KITTITAS COUNTY

DEPARTMENT OF PUBLIC WORKS

MEMORANDUM

TO: All Staff
FROM: Public Works Plan Review Team
DATE: June 22, 2026
SUBJECT: SP-26-00004 Moulton

<h2>Hazardous Slope</h2>	
	<h1>2026</h1>
Coordinate System: NAD 1983 StatePlane Washington South FIPS 4602 Feet

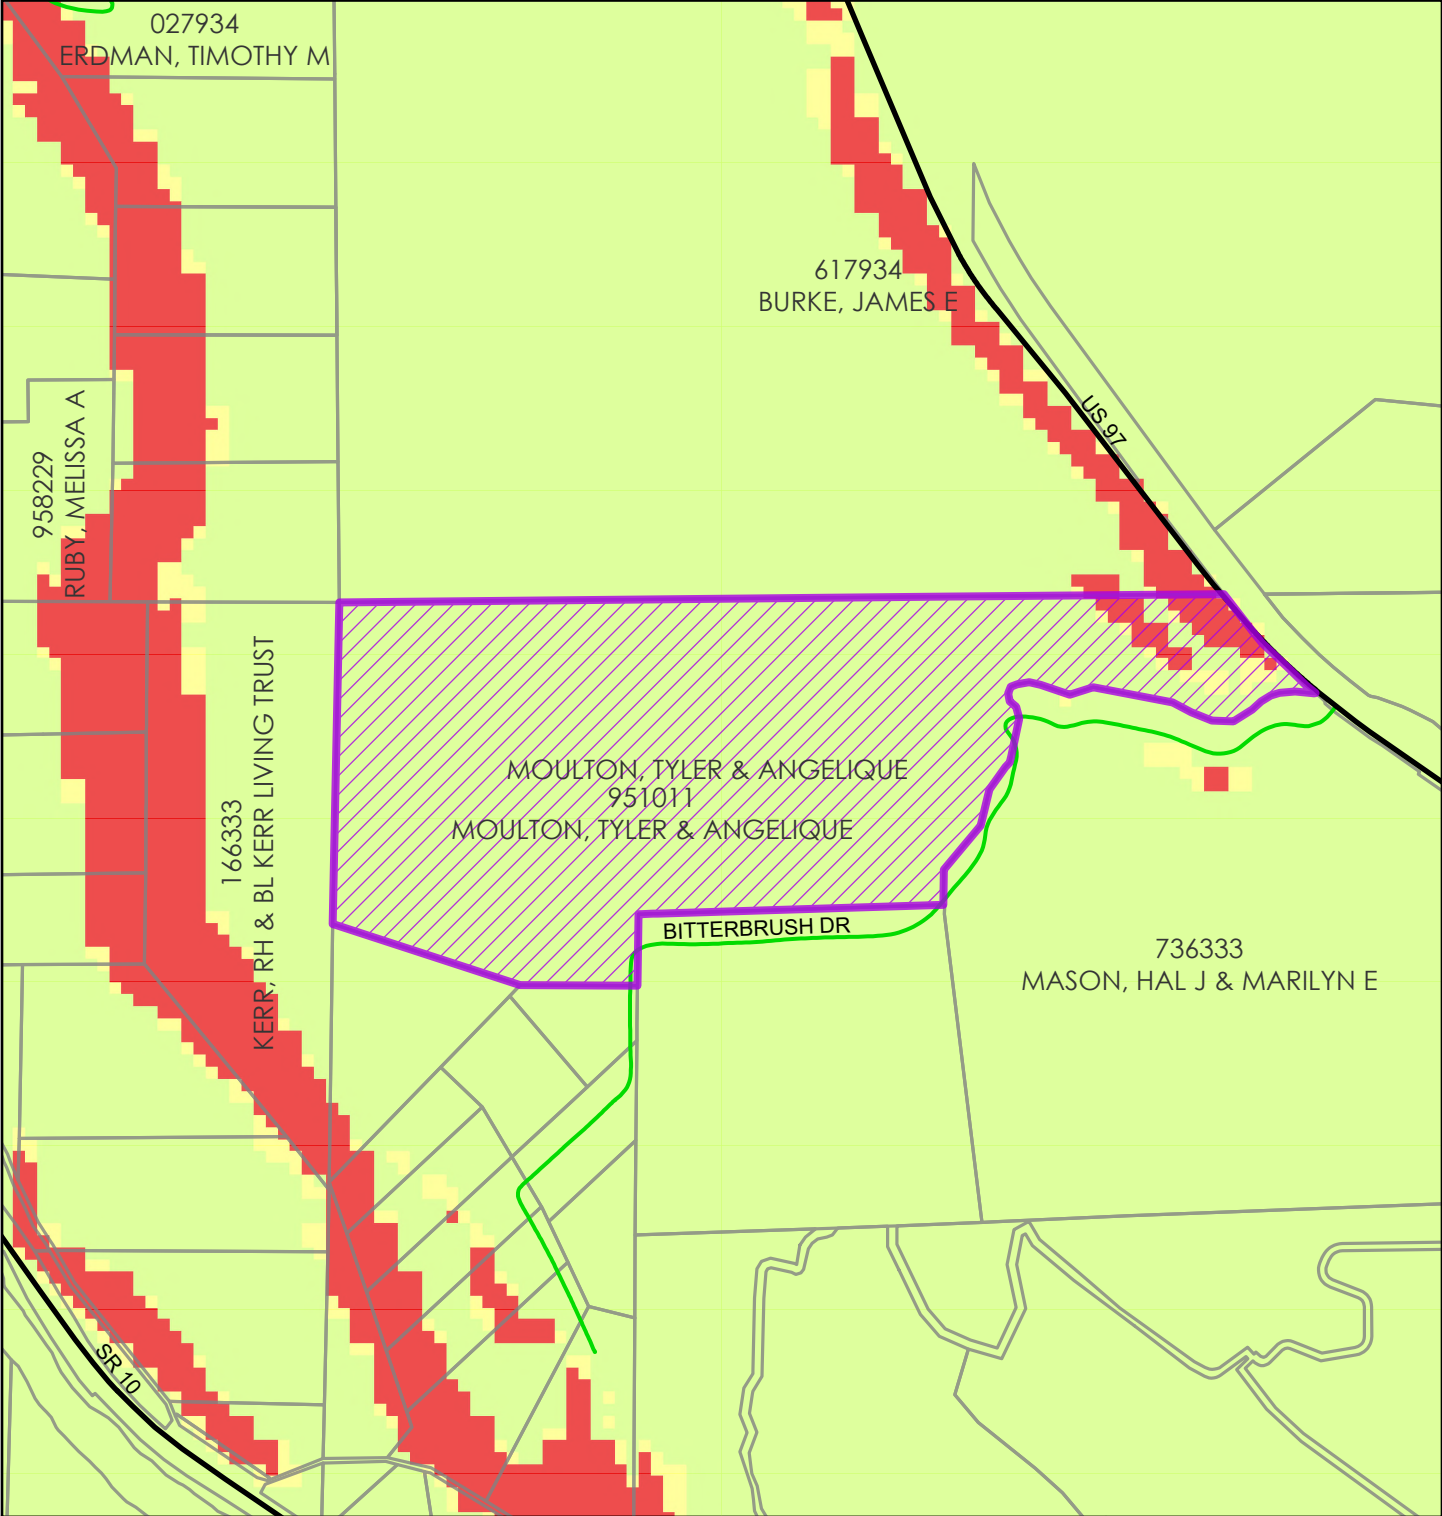
FLOOD	Parcel #951011 is not mapped within a FEMA identified special flood hazard area (1% annual chance flood zone). Floodplain development permitting is not required for the proposed project. (SC)
WATER MITIGATION/ METERING	The following comments outline the requirements for legal availability of water and metering for the proposed short plat: The applicant must provide legal water availability for all new uses on the proposed lots of this project. Prior to final plat approval and recording, the following conditions shall be met: In accordance with KCC Chapter 13.35.027, the applicant shall provide one of the following documents before final plat approval: 1. A letter from a water purveyor stating that the purveyor has adequate water rights and will provide the necessary water for the new use; 2. An adequate water right for the proposed new use; or 3. A certificate of water budget neutrality from the Department of Ecology or other adequate interest in water rights from a water bank. All applicants for land divisions shall also submit information on "proximate parcels" held in "common ownership" as those terms are defined in WAC 173-539A-030 and otherwise demonstrate how the proposed new use will not violate RCW 90.44.050 as currently existing or hereafter amended. Failure to obtain mitigation before commencement of an activity requiring mitigation shall be a code violation subject to enforcement under Title 18 KCC. Final Plat Notes The following notes shall be placed on the face of the plat: C-1 "Metering is required for all new uses of domestic water for residential well connections and usage must be recorded in a manner consistent with Kittitas County Code Chapter 13.35.027 and Ecology regulations." C-2 "The approval of this division of land provides no guarantee that use of water under the ground water exemption (RCW 90.44.050) for this plat or any portion thereof will not be subject to curtailment by the Department of Ecology or a court of law." (SC)

MOULTON SHORT PLAT

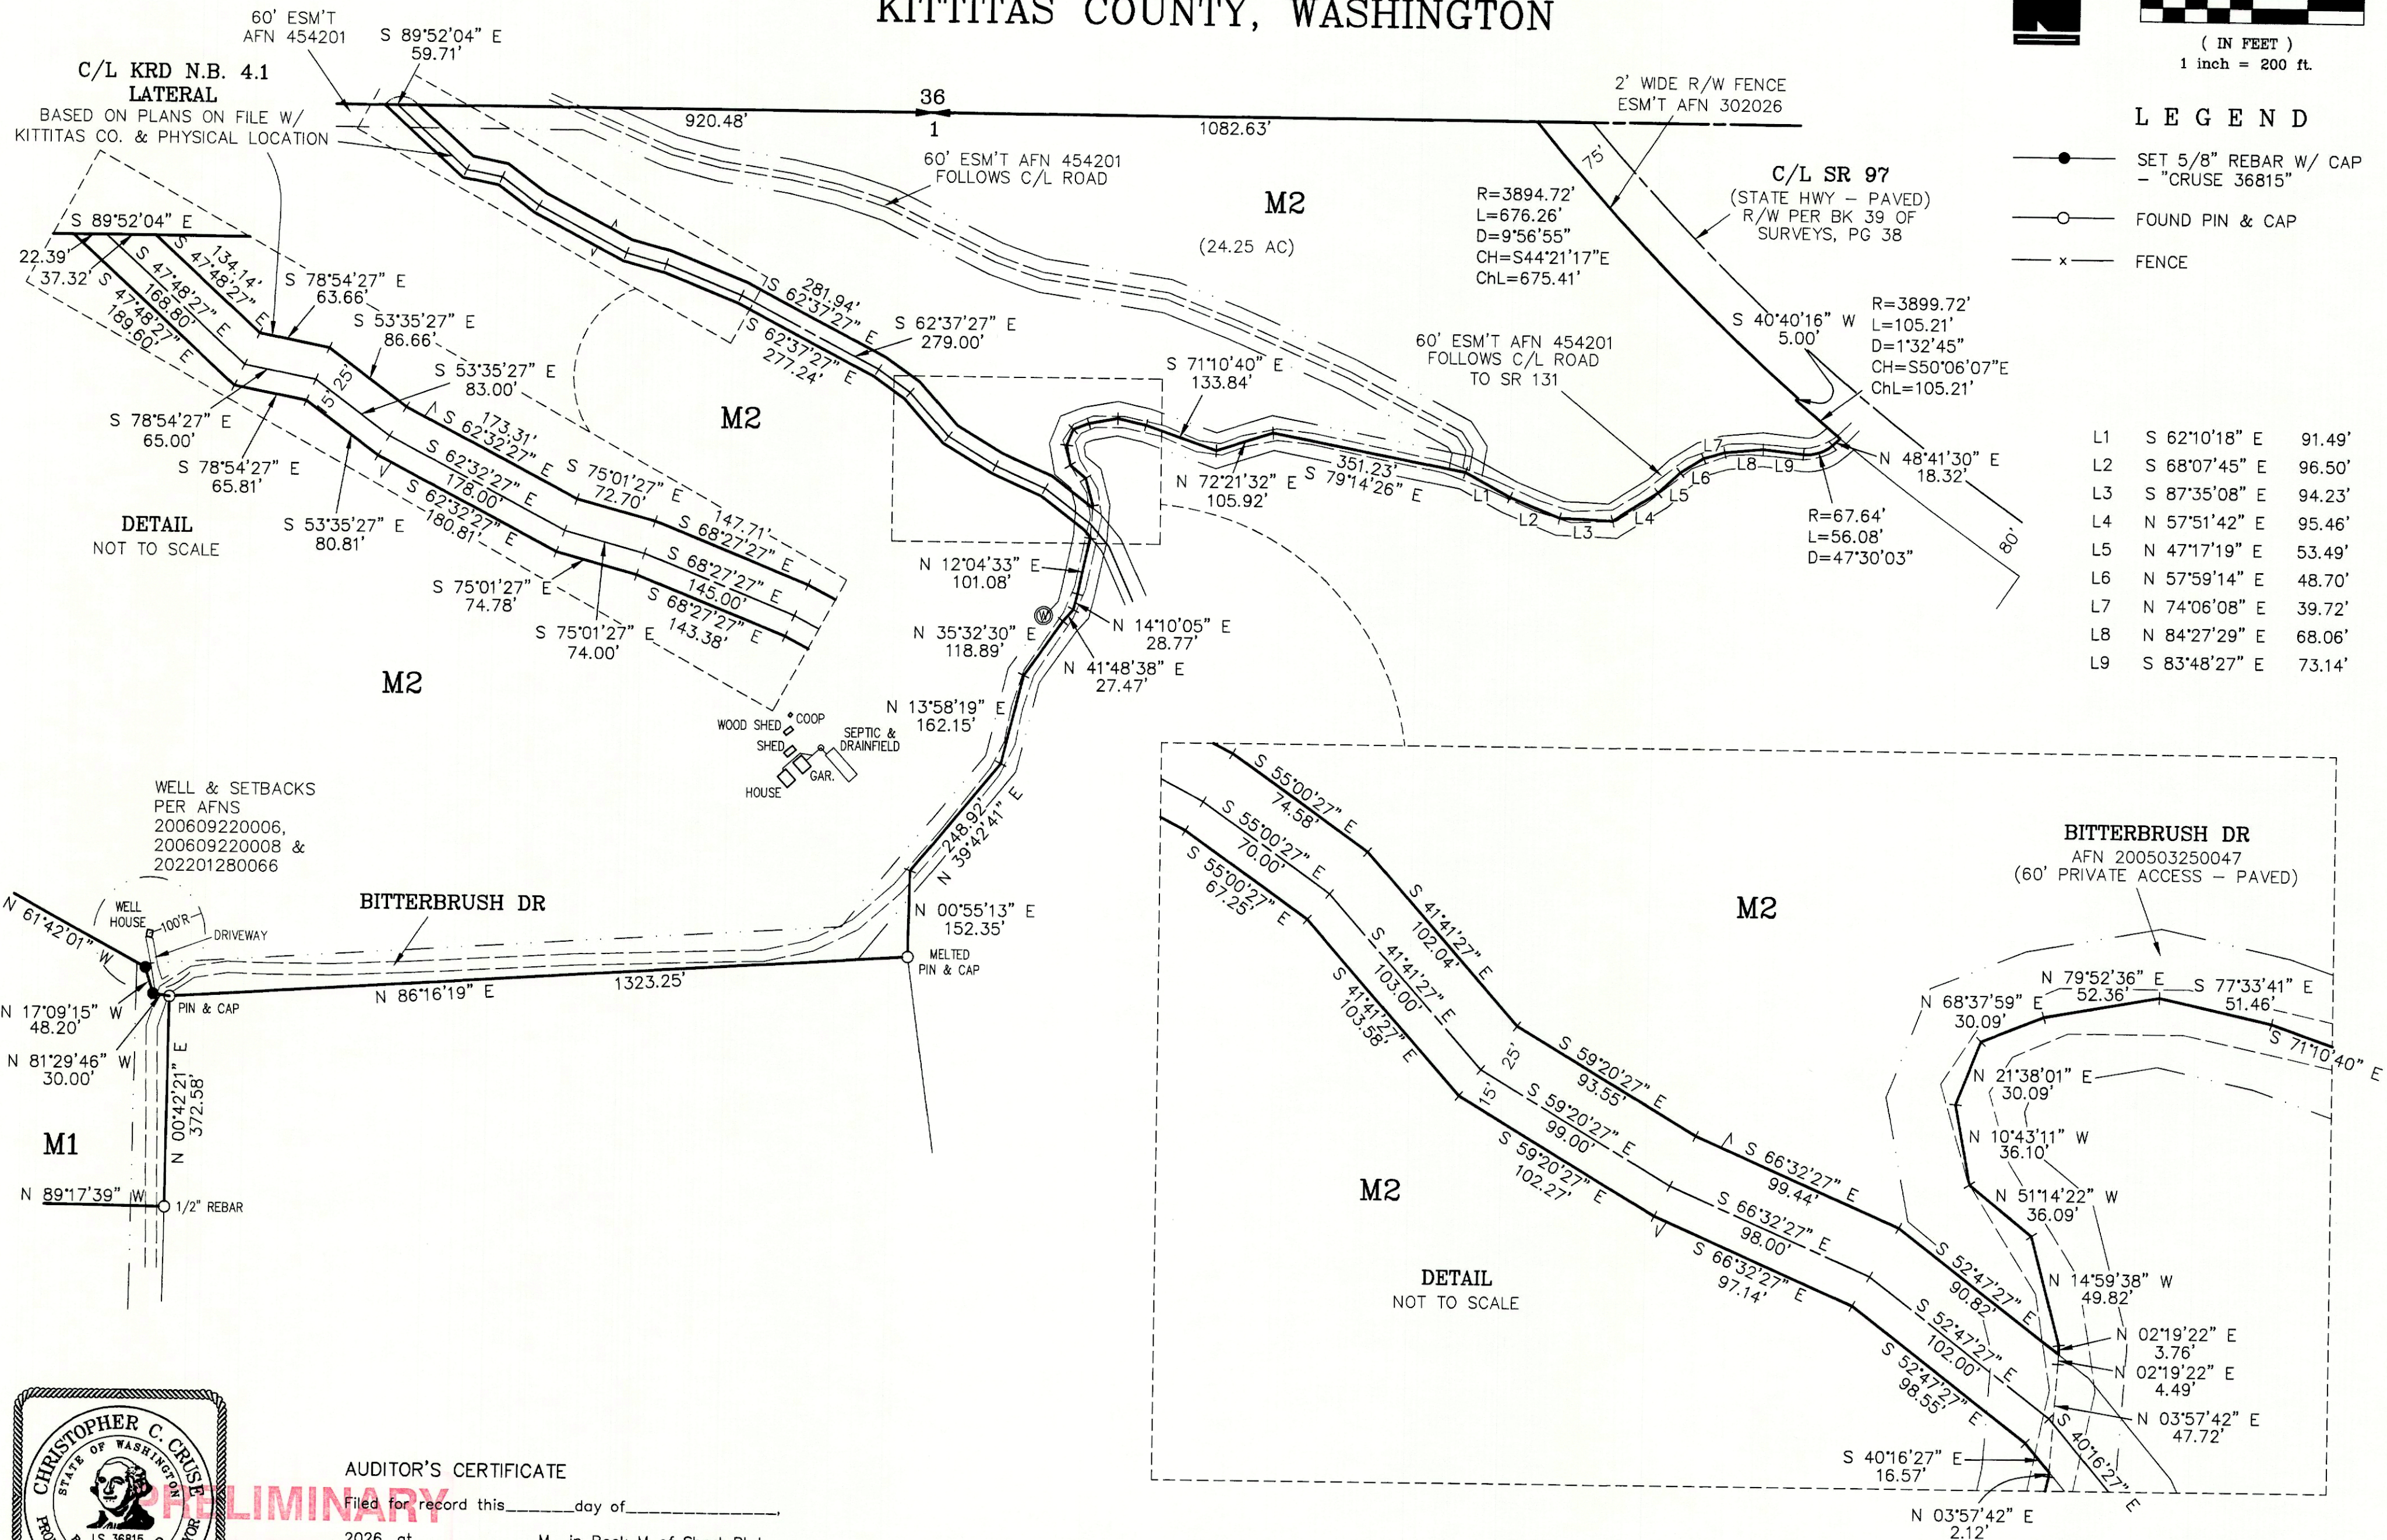
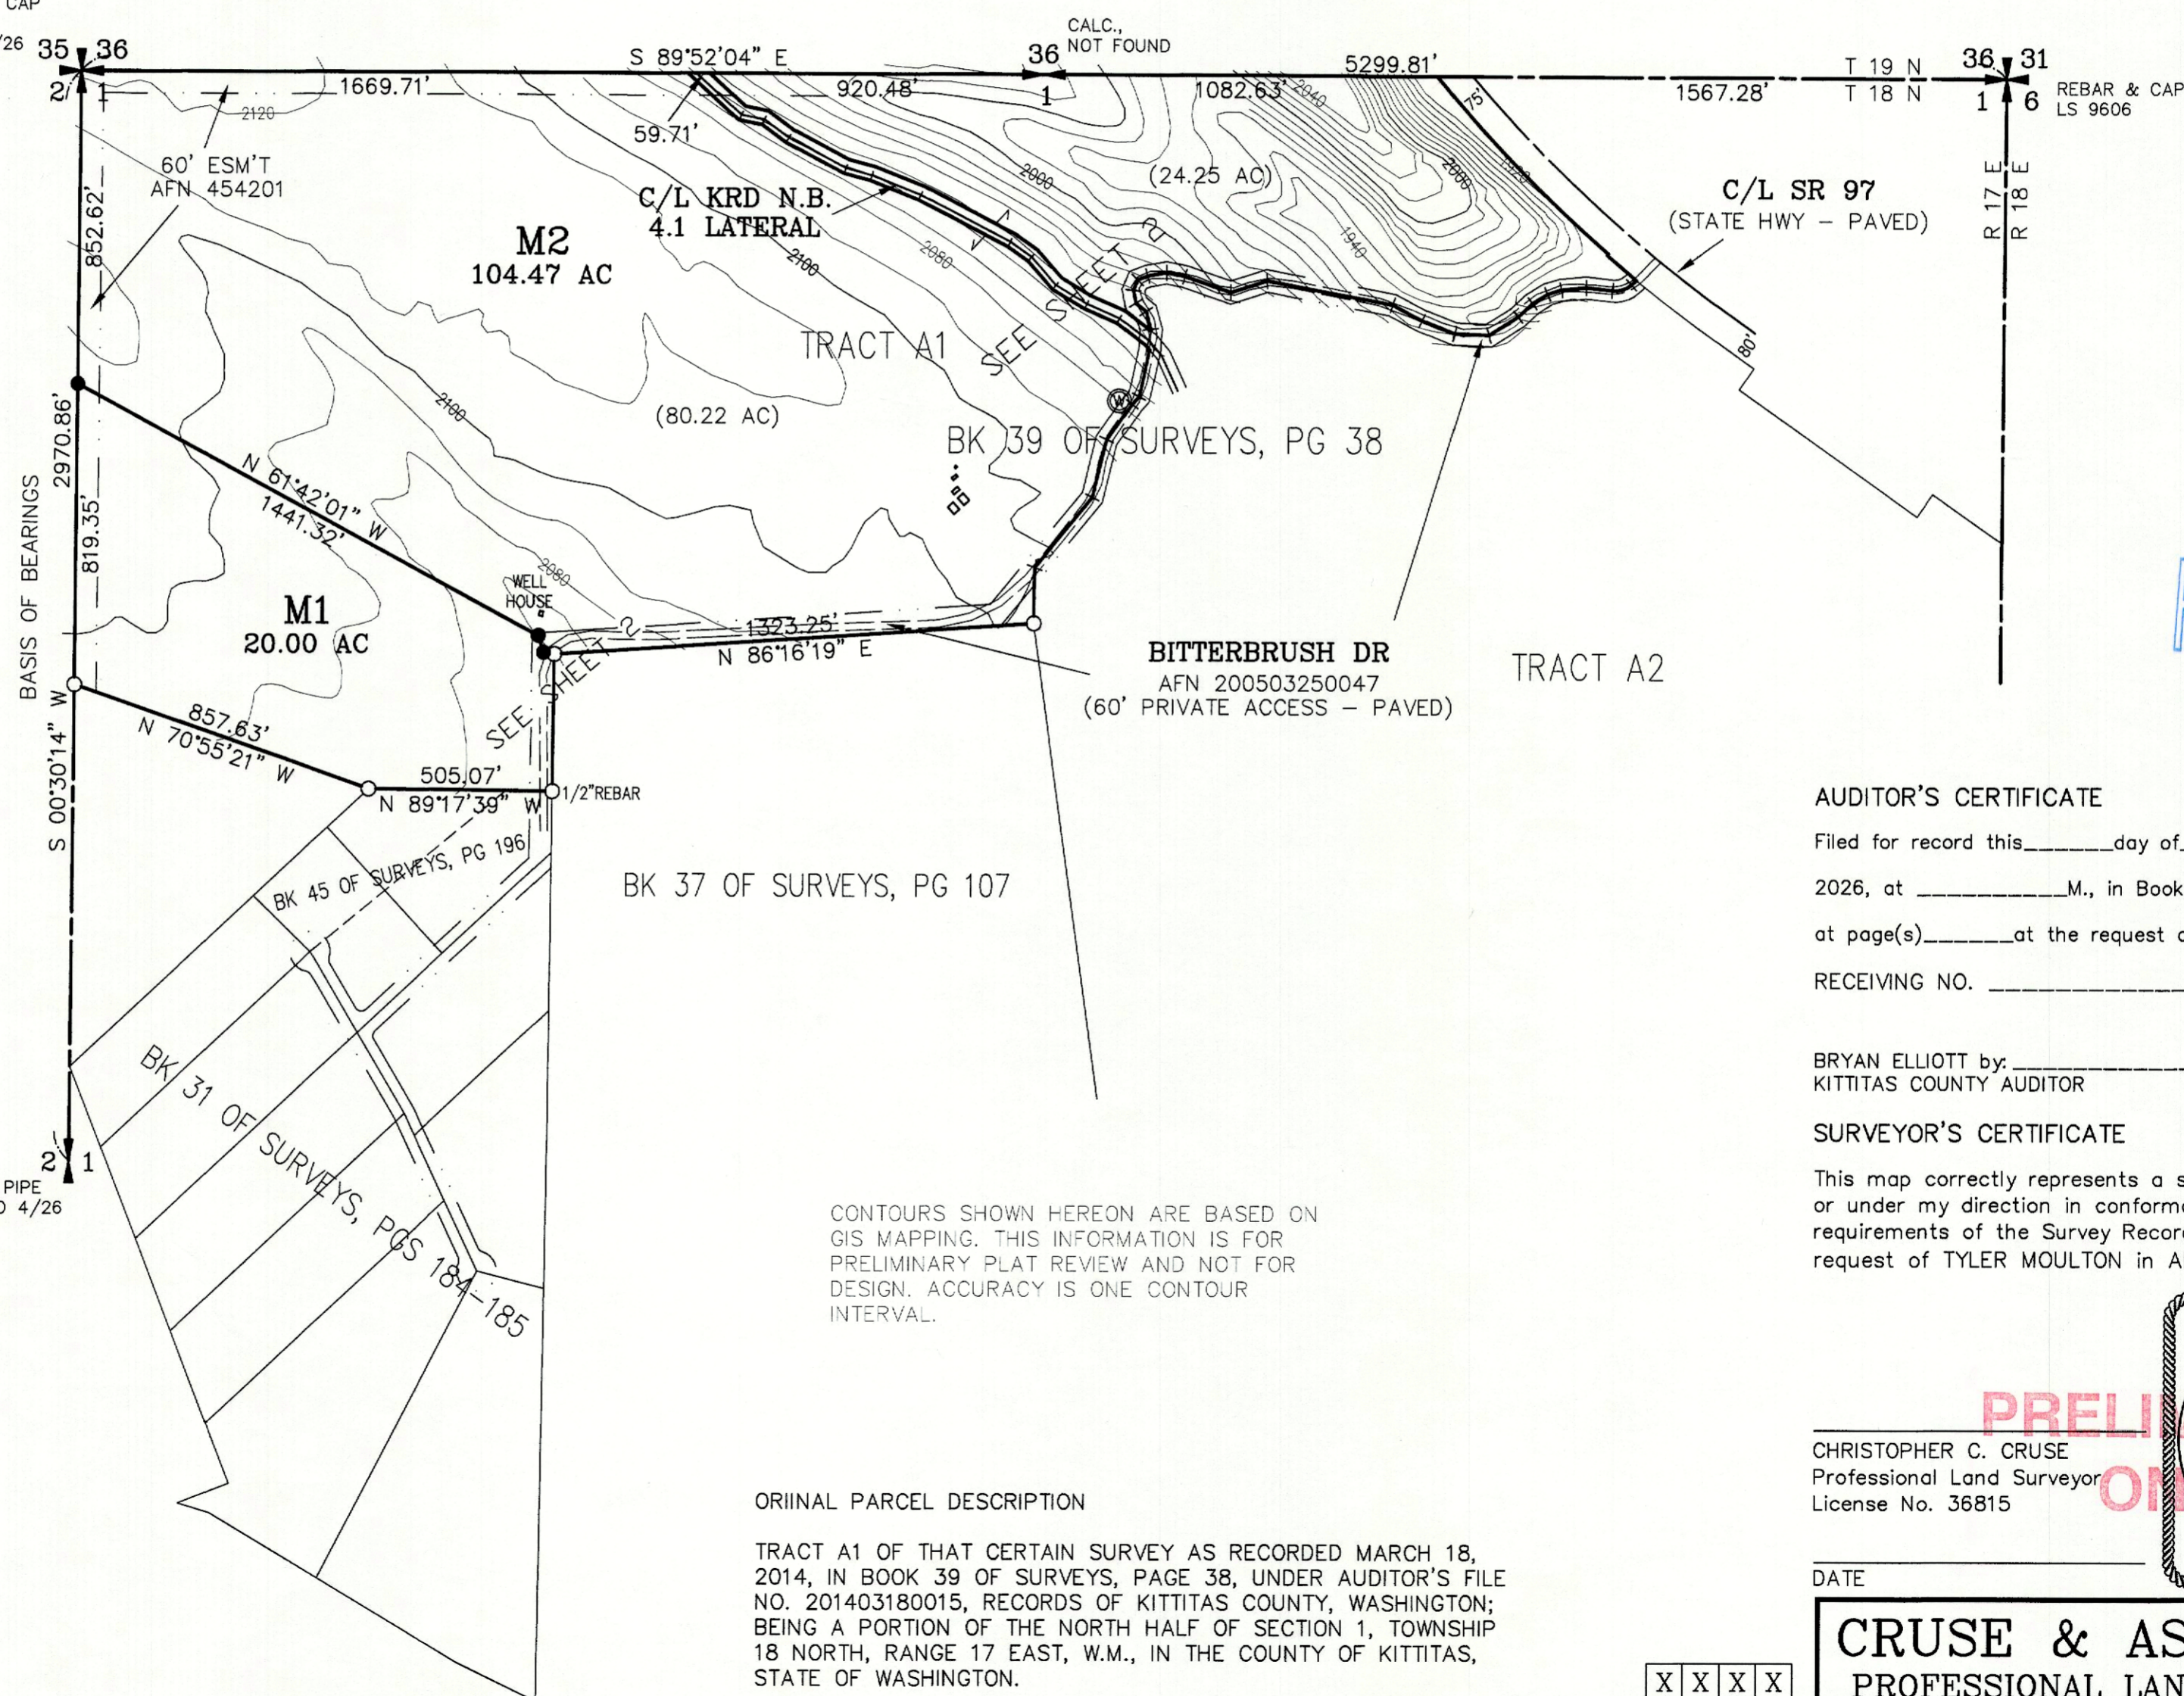
ACCESS	1. An approved access permit shall be required from the Kittitas County Department of Public Works prior to creating any new driveway access or altering an existing access. 2. Maintenance of driveway approaches shall be the responsibility of the owner whose property they serve. The County will not maintain accesses. 3. Any further subdivision or lots to be served by proposed access may result in further access requirements. See Kittitas County Road Standards. In addition to the above-mentioned conditions, all applicable Kittitas County Road Standards apply to this proposal. Access is not guaranteed to any existing or created parcel on this application.(RC) OF Note: -WSDOT Approved Access Permit allows for up to 100 lots to be served by this access. -For future development on Bitterbrush Dr. The current lot size averages 22.65 acres between 15 lots. If the average lot size ≤ 10 acres, then road improvements will be required according to KCC Title 12 Table 12.04.04-1.

ENGINEERING	Except as exempted in KCC 14.05.060, no grading or filling upon a site involving more than one hundred (100) cubic yards shall be performed without a grading permit County Engineer or Public Works designee (KCC 14.05.050). An application for grading in excess of five hundred (500) cubic yards shall be accompanied by an engineered grading plan (KCC 14.05.080). (CBP)
SURVEY	There are no survey comments regarding this application. (JT) OF NOTE Lot closures and subdivision guarantee were not provided and will need to be reviewed at final.
TRANSPORTATION CONCURRENCY	No Comments.(RC)
